Application for Removal or Variation of a Condition following Grant of Planning Permission or Listed Building Consent

Demolition of existing modern farm buildings and conversion of Dutch Barn to form 1no. dwelling. Re-roofing of existing outbuilding to form carport with associated works.

P20/07553/F

Condition 9- Drawings

Drawing Title:-
Proposed First Floor Plan

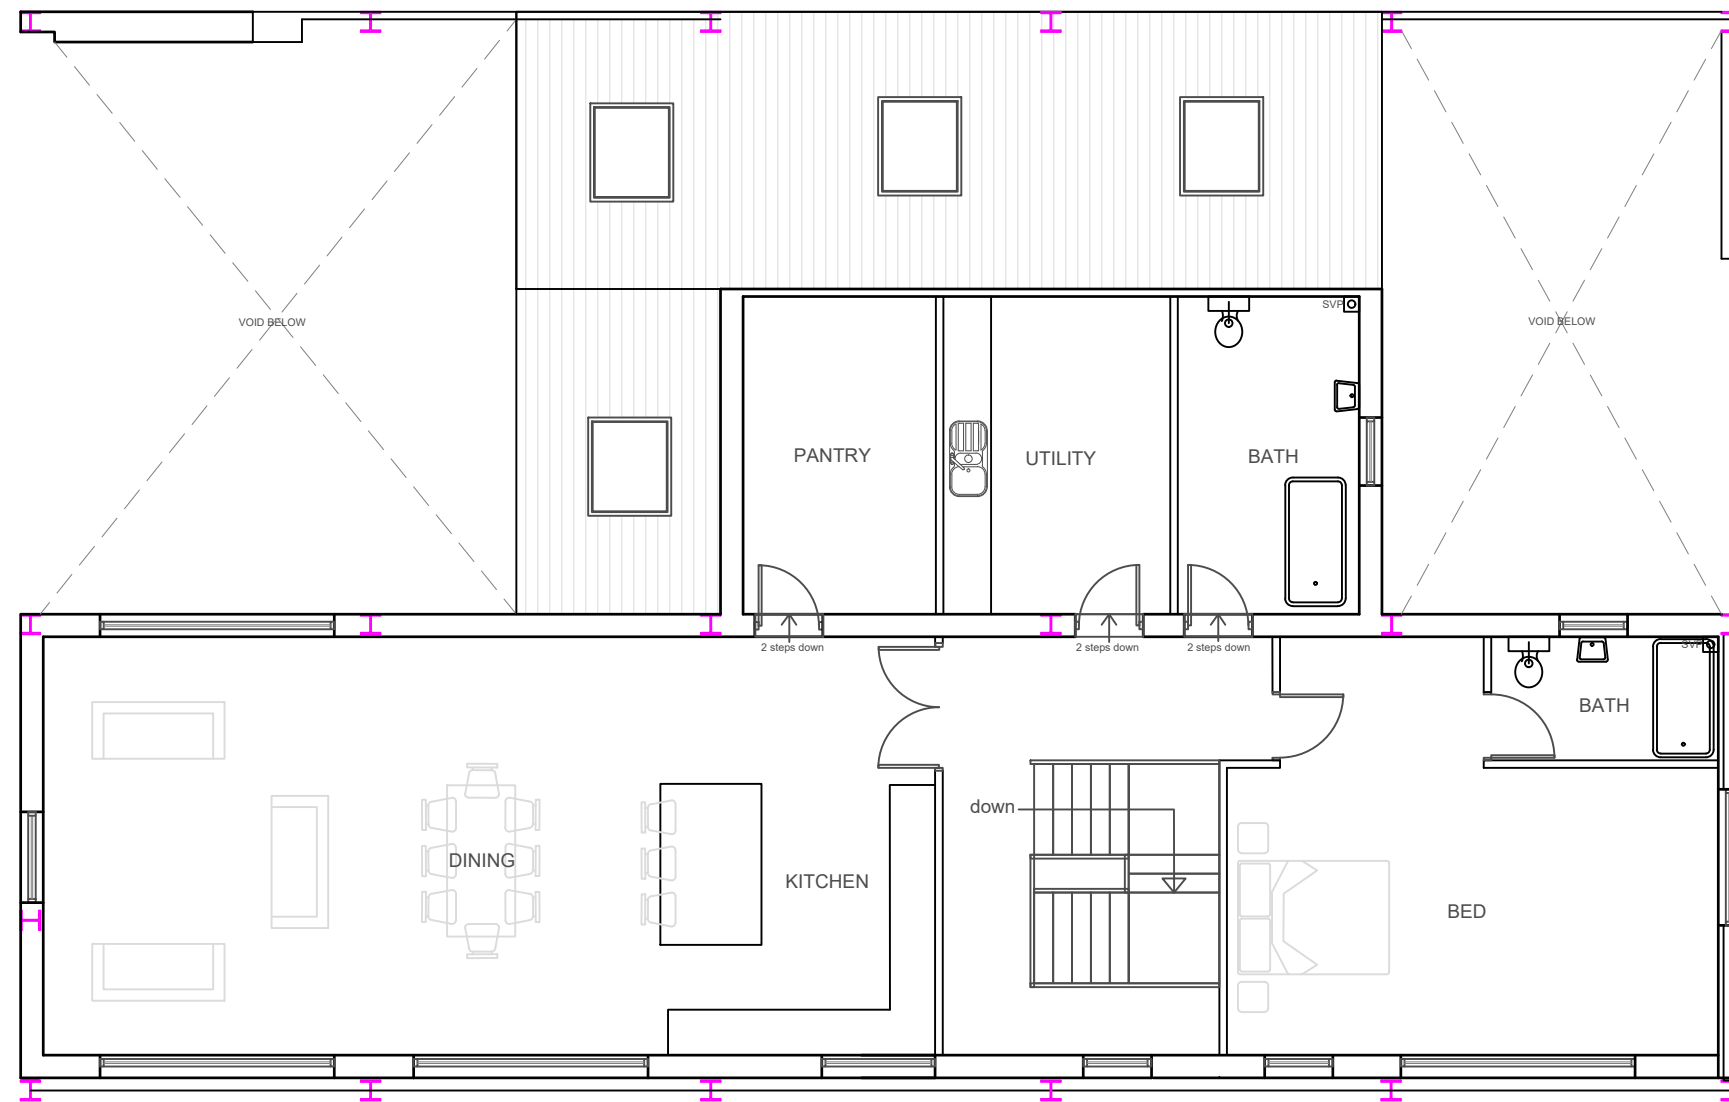
Swapp old drawings for new, to show position and size of windows and doors that have been amended

Proposed First Floor plan (Drawing No. 20.02.03.12)

Proposed First Floor Plan RM010- 06 Jan 24

Drawing Title:-  
Proposed Ground Floor Plan

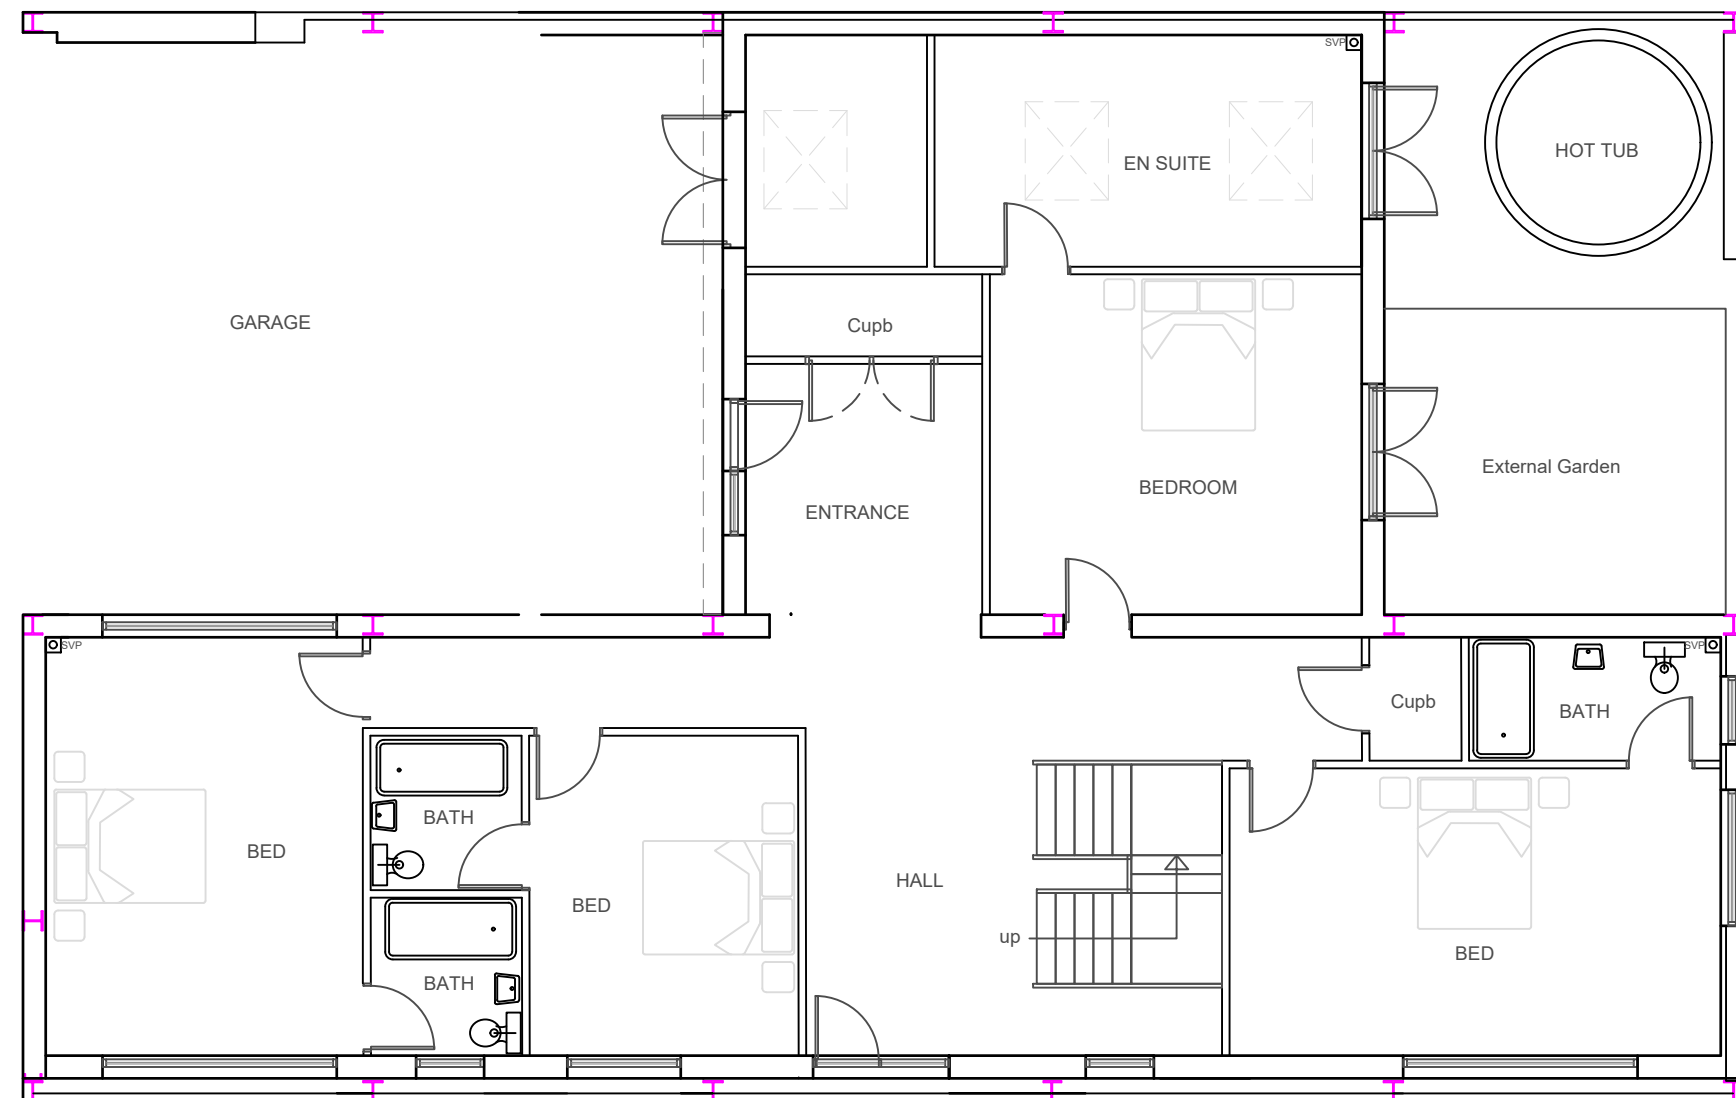
Proposed Ground Floor Plan (Drawing No. 20.02.03.11 Rev A)

Proposed Ground floor plan RM010- 05 Jan 24
